From: [REDACTED]
Sent: 04 December 2024 22:01
To: [REDACTED]; Planning
Subject: Objection 26 Singleton Avenue Read Burnley. Application 3/2024/0658
Attachments: IMG-20241204-WA0005.jpg; IMG-20241204-WA0003.jpg; IMG-20241204-WA0004.jpg; IMG-20241204-WA0002.jpg; Installation guide.eml

Re - Application 3/2024/0658 objection.

This is our formal objection to the planning application of the above property for the retention of the air source heat pump erected within 1m of the boundary and the amended plan dated 27/11/2024 to move the unit and box it in.

PROPOSED ACOUSTIC ENCLOSURE DETAILS:

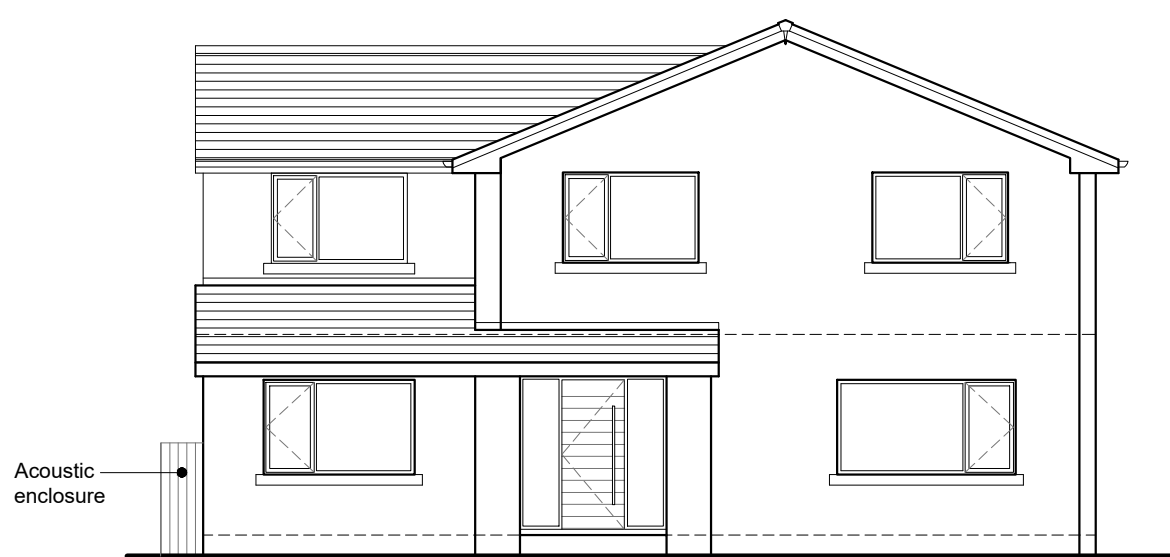
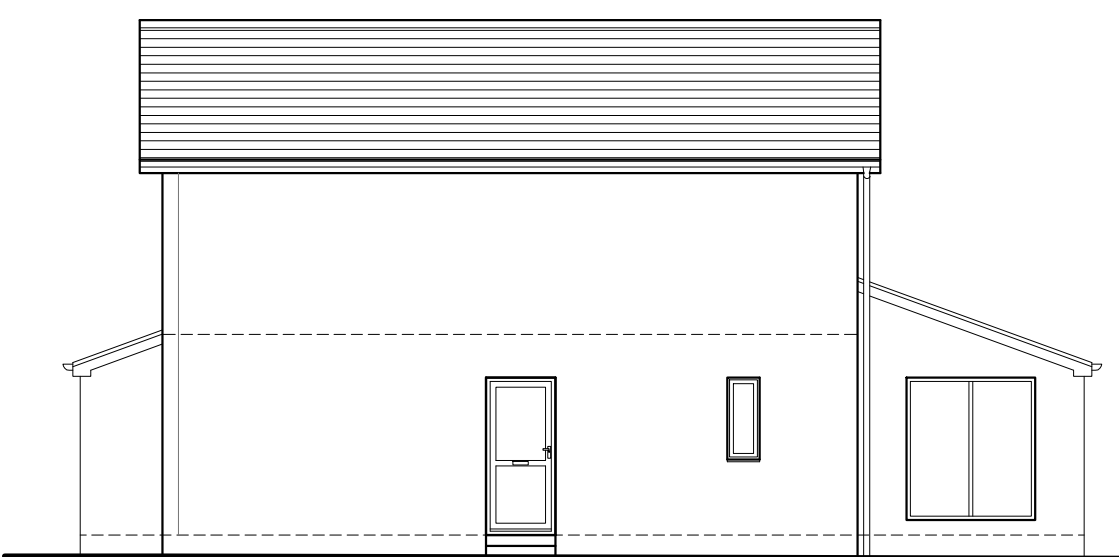
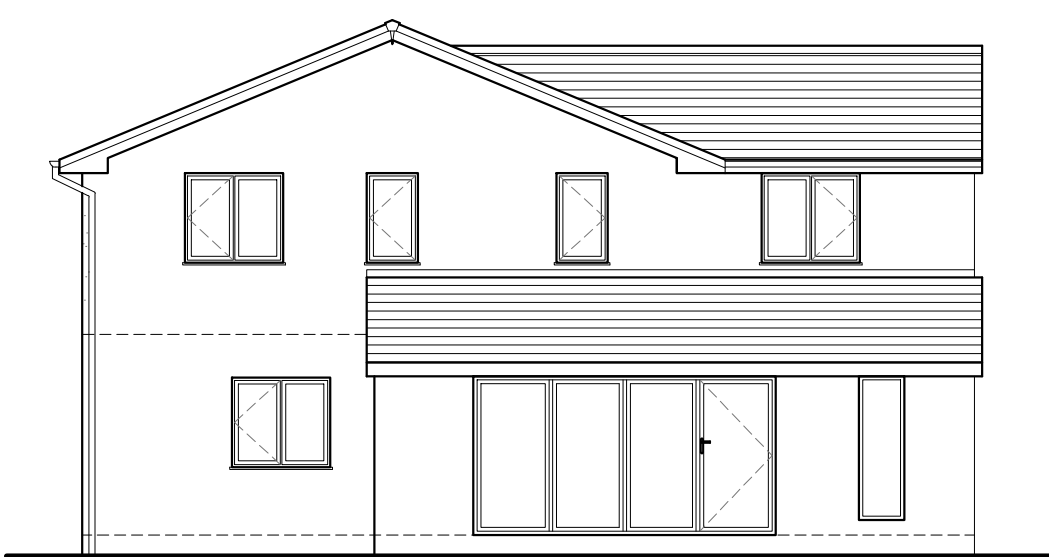
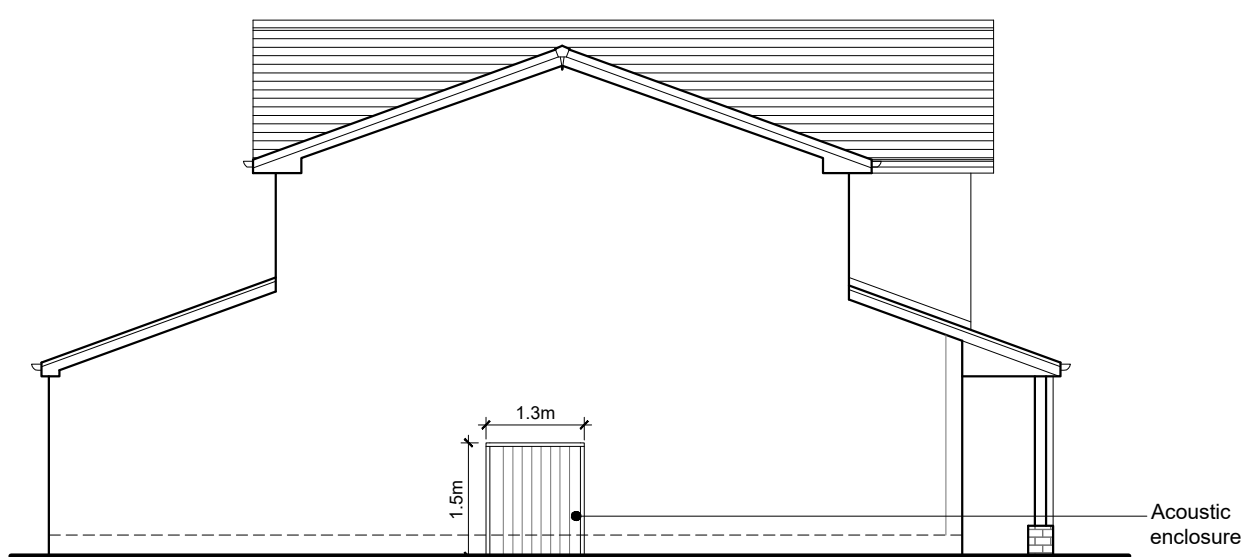
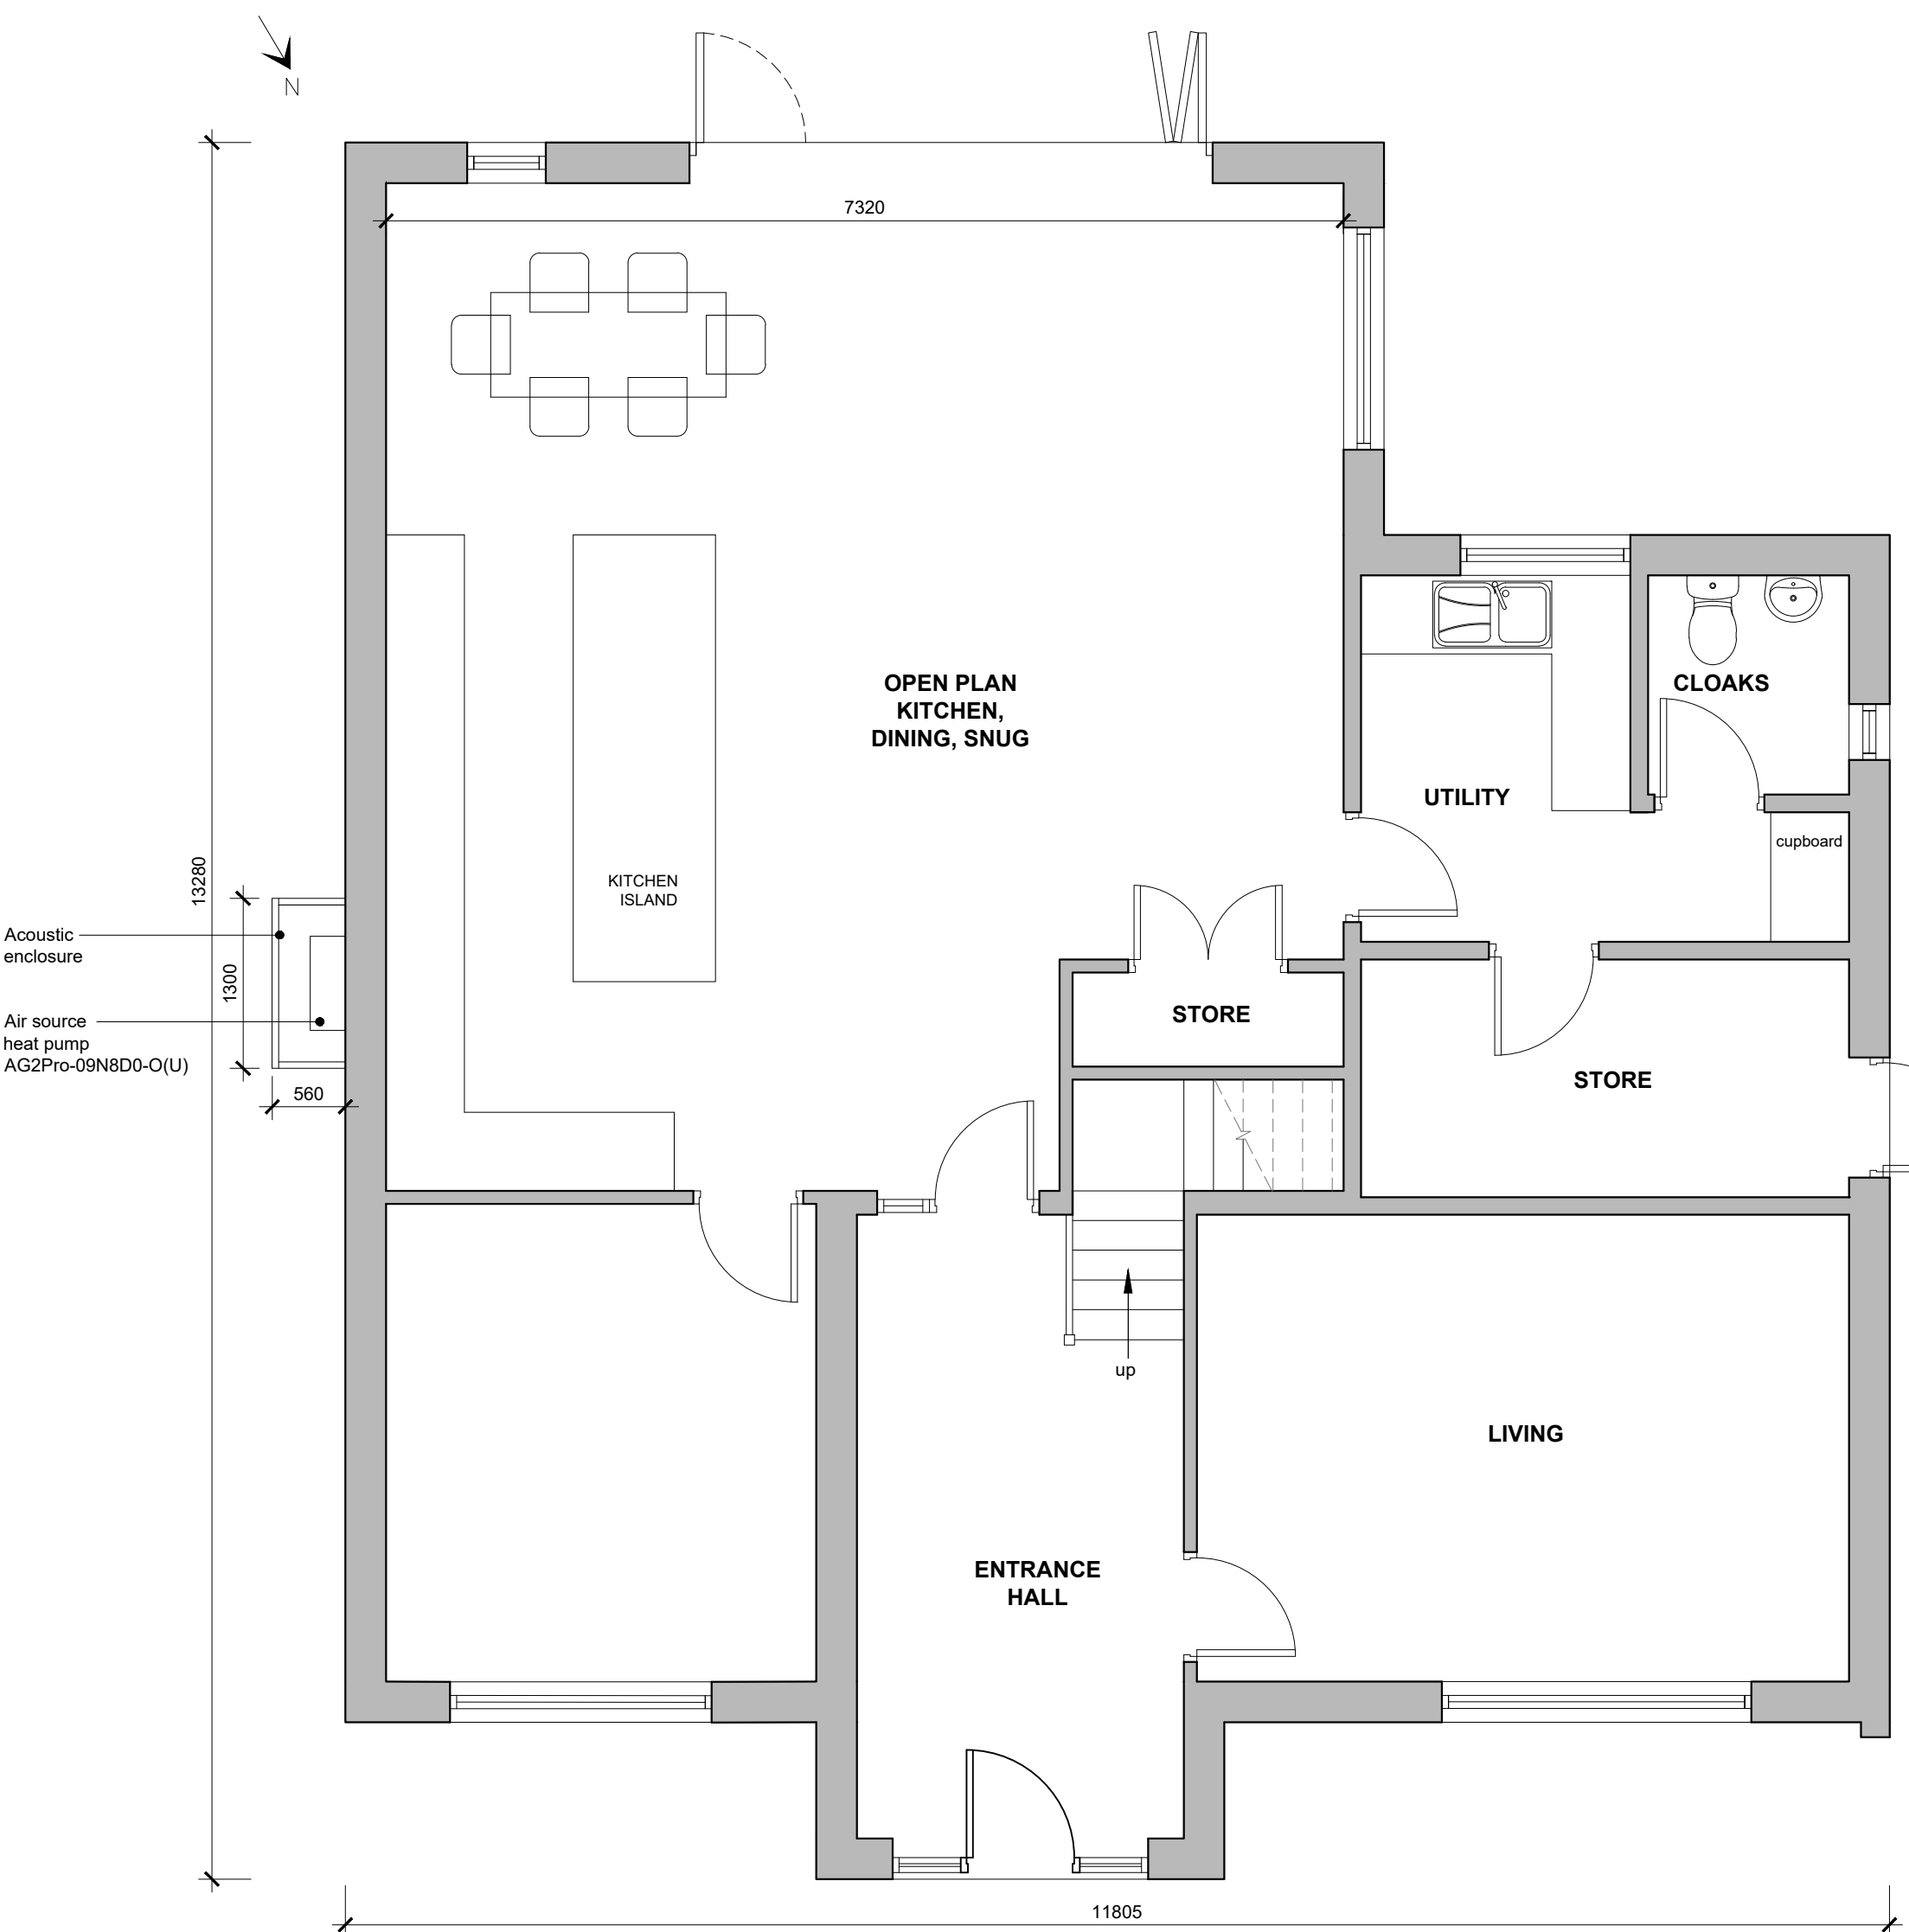
Attached are the manufacturer's instructions for the unit installed at 26 Singleton Avenue. This was obtained directly from [REDACTED] and an email trail can be provided if required. On page 25, it bullet points the installation instructions for the outdoor unit and the first point states that the unit should meet all spatial requirements shown in installation space requirement above. The above diagram gives dimensions for the spatial requirements, 30cm from the left of the unit, 60cm to the right of the unit, 30cm from the wall it is mounted on and 200cm from the front. [REDACTED] feel that the proposed boxing detailed on the plans would contravene the installation instructions for this unit as the space is not available to the front of the unit, nor is there enough room to mount the unit with 30cm of clearance to the rear.

Furthermore, we have attached measurements taken from the wall ([REDACTED]) to the [REDACTED] [REDACTED] The boxing measurement in the proposed plans shows the boxing depth as being 0.6m. As shown on the measurement photographs this would mean the boxing is over the [REDACTED] onto the fence.

This amended proposal does not improve the visual aspect [REDACTED], as this is [REDACTED]

[REDACTED] feel that the amended plans do not go far enough to resolve the situation and also contradict the manufacturer's installation instructions which [REDACTED] feel is a time wasting exercise.
